CIMARRON HILLS FIRE DEPARTMENT

April 17, 2024

Subject: My Garage at Northcrest (AL243)

Key Elements: 2018 International Fire Code (IFC) Aerial Fire Apparatus Access Roads

DRAWING NO.  
1  
SPECIAL USE PLAN

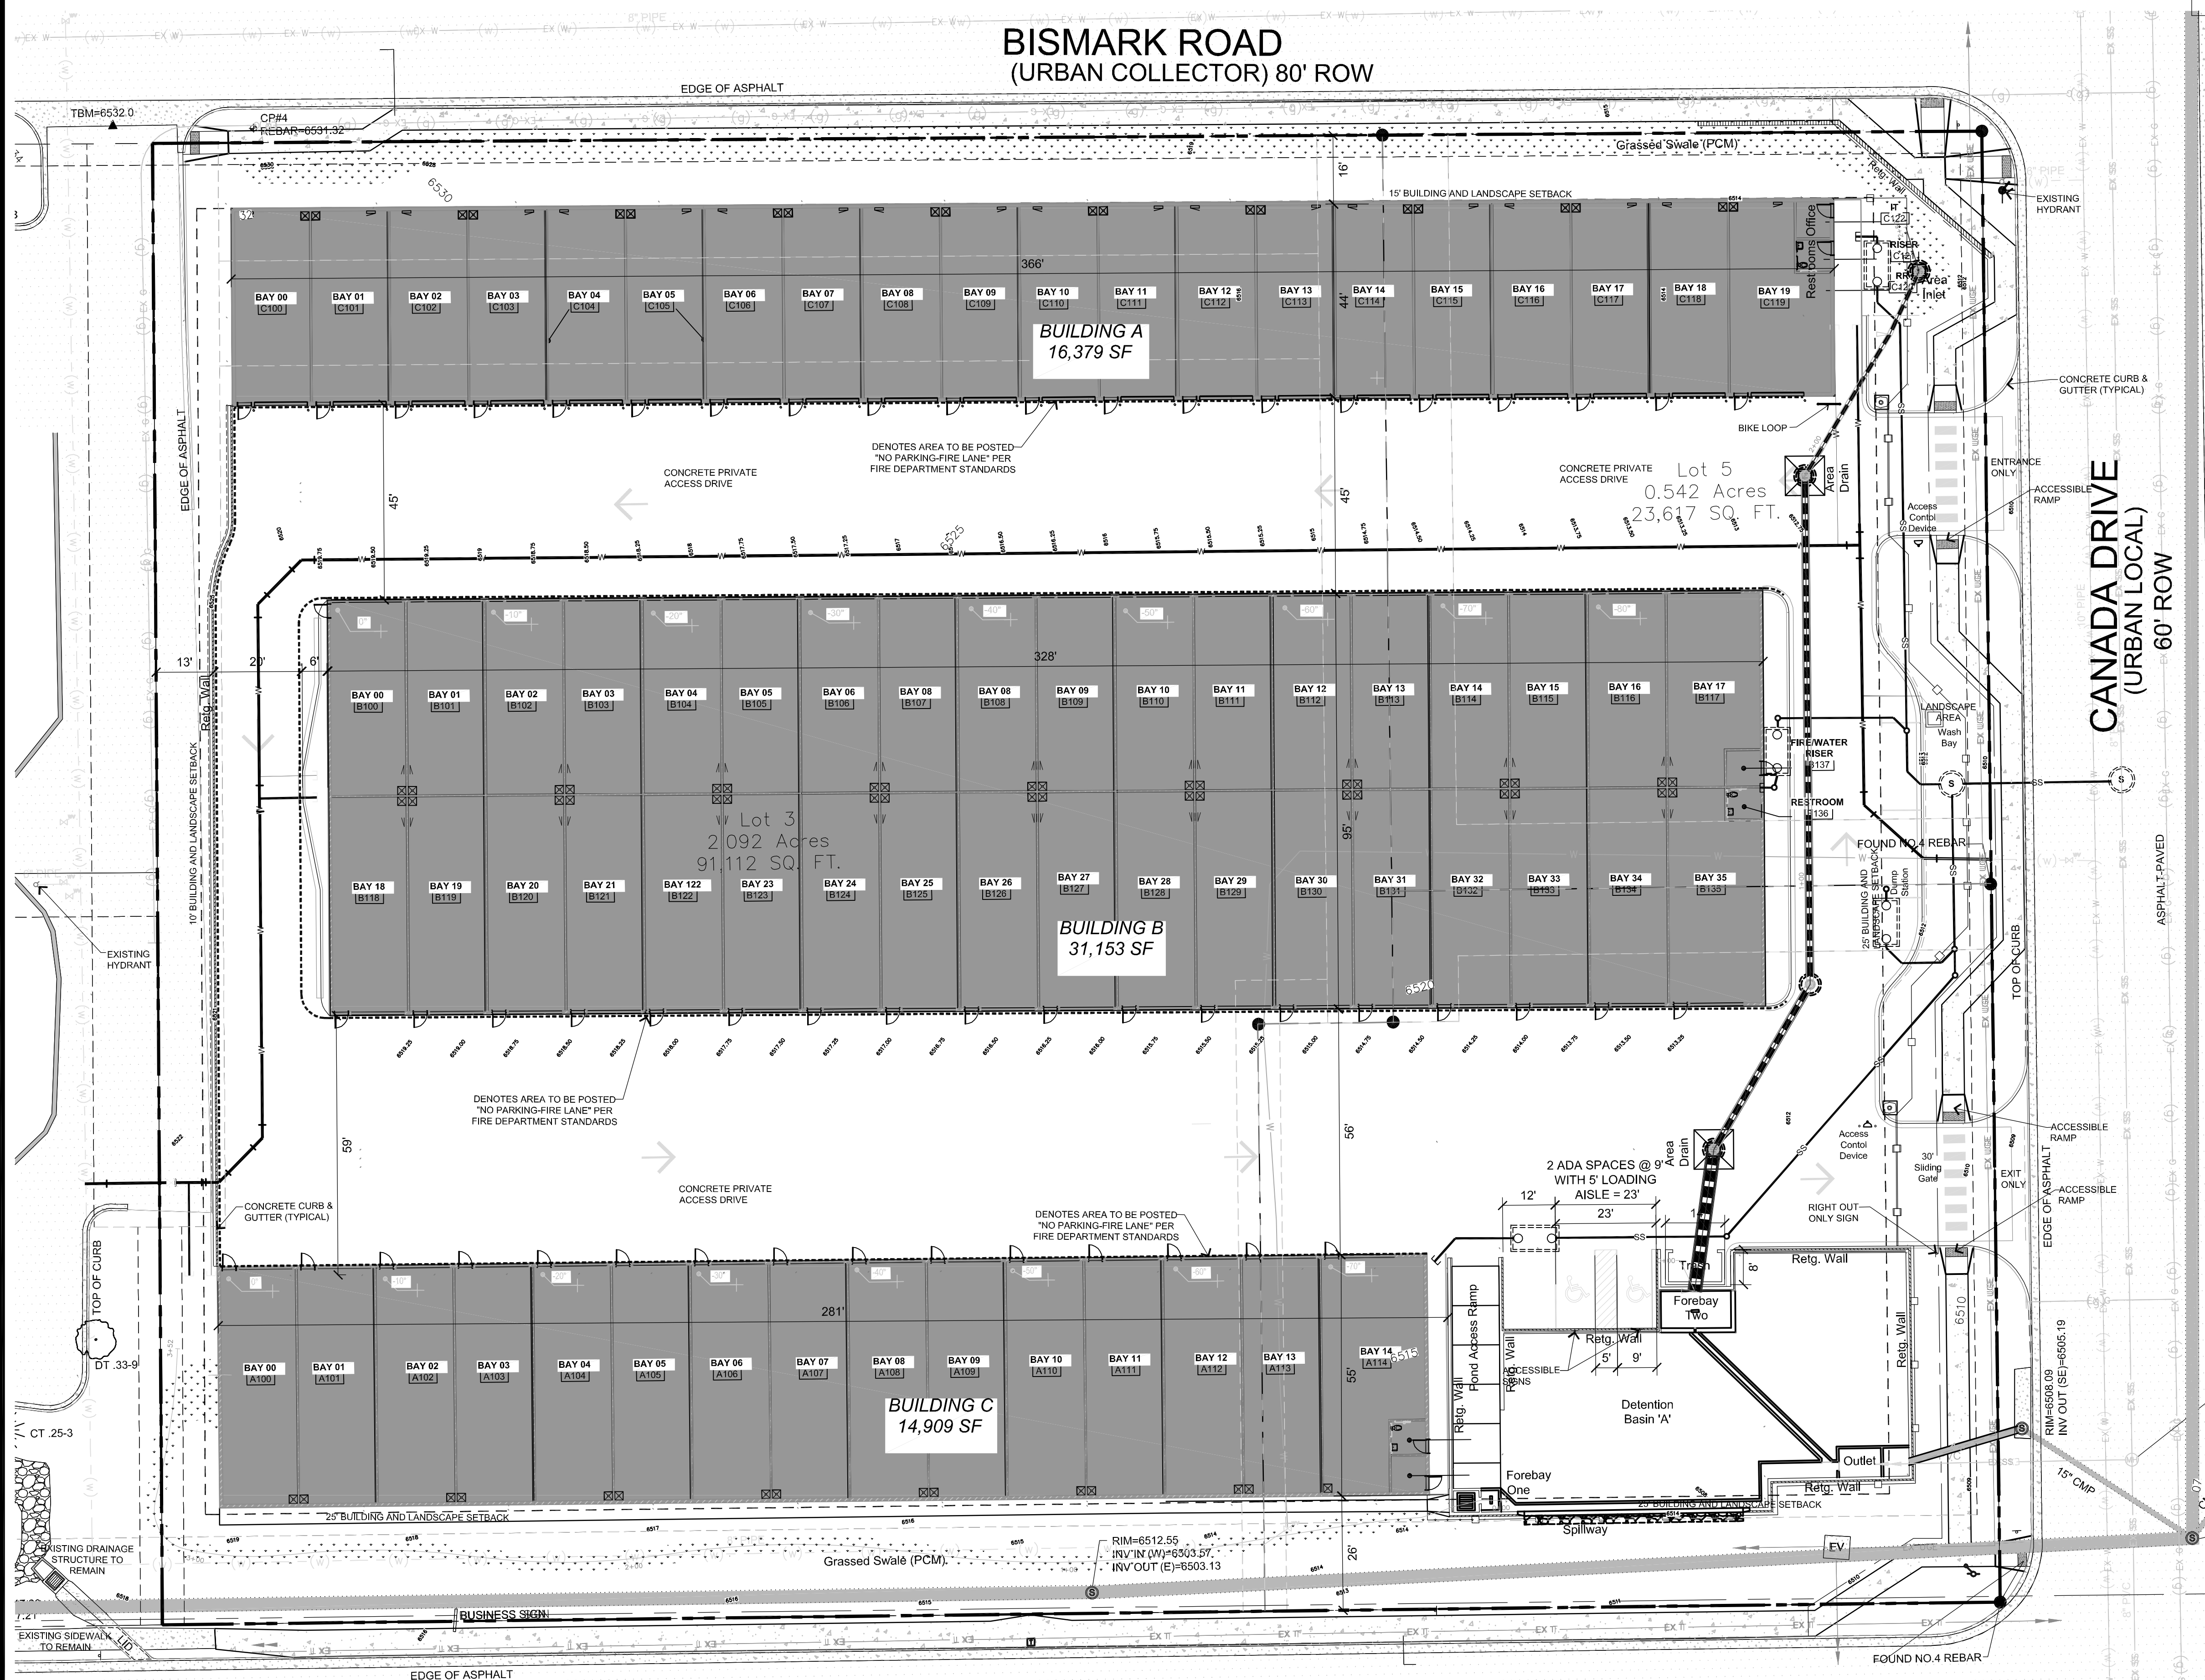
The Cimarron Hills Fire Department (CHFD) has reviewed the My Garage at Northcrest Project and is providing the following comments. This is a request for a review of fire department aerial ladder trucks requirements for a minimum turning radius due to the length of the apparatus, wheelbase, and steering capabilities. Identifying any potential challenges such as narrow streets, tight corners, low clearances, or obstacles that could impact the truck's turning radius or operational effectiveness.

- Typically, the minimum outside turning radius for required access roadways is around 42 feet. Ladder Truck access is necessary, a greater radius (up to 60 feet) might be required.

- Fire apparatus access roads should also have a minimum inside turning radius of at least 25 feet. This provides adequate space for the long wheelbase of fire trucks to make turns.
